From: Mike Wainwright [REDACTED]
Sent: 29 May 2013 19:17
To: Susan Leeson
Cc: Planning
Subject: Planning Application BR/41/13

With reference to the planning application BR/41/13:

Demolition of existing buildings and redevelopment of the site with 6 two bedroom dwellings on land to the rear of 'Holmlea' Town Cross Avenue, Bognor Regis PO21 2DN

PROPOSED ELEVATIONS ~ PLOTS 2 & 3

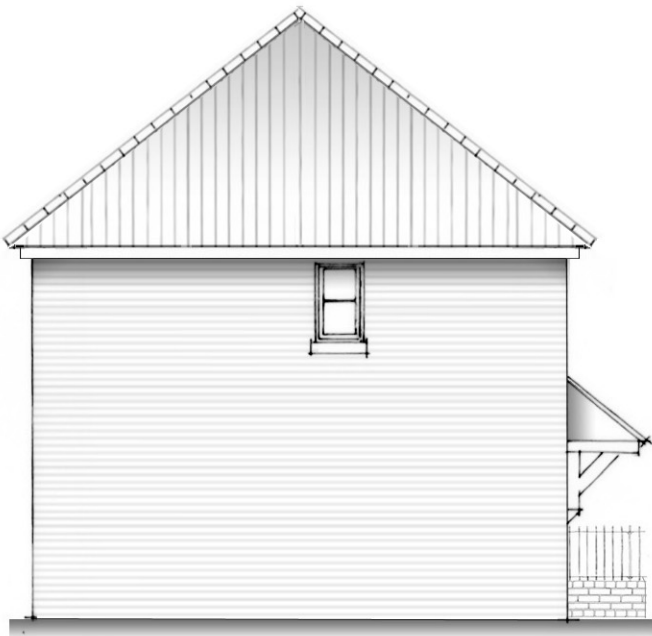
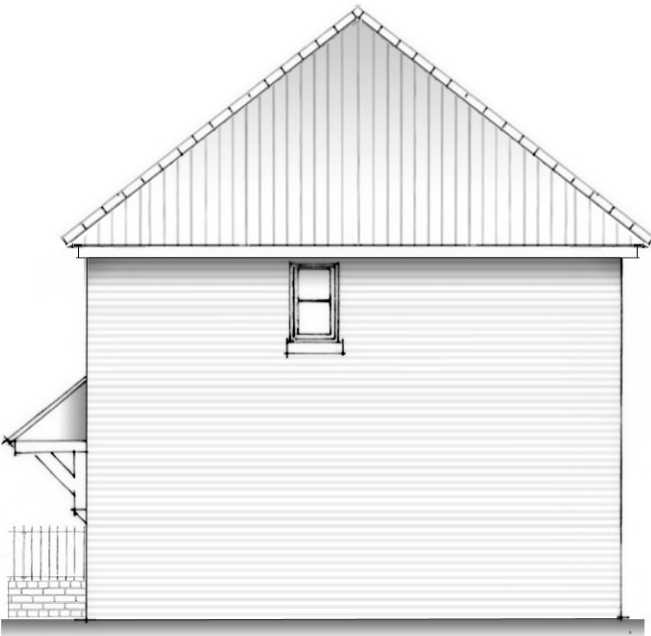
The layout of the proposed development is completely overbearing to my property and the others bordering the site from Essex Road. All front elevation windows of plots 2 and 3 would look directly into mine and my neighbours gardens. Furthermore, the proposal to remove the existing brick wall, which provides structural integrity for all the dividing walls between the properties in Essex Road, is in my view designed to allow the proposed properties an even better view into our gardens! Why else would a perfectly sound wall that is about 135 cm in height be replaced with a less permanent wooden fence of only 120 cm? This can only be proposed in order to make the oppressively overcrowded development *appear* less overcrowded! Can I ask who is going to maintain this fence after the properties are sold, and who would be liable if removal of the wall caused one of the adjoining walls to fall down in the future?
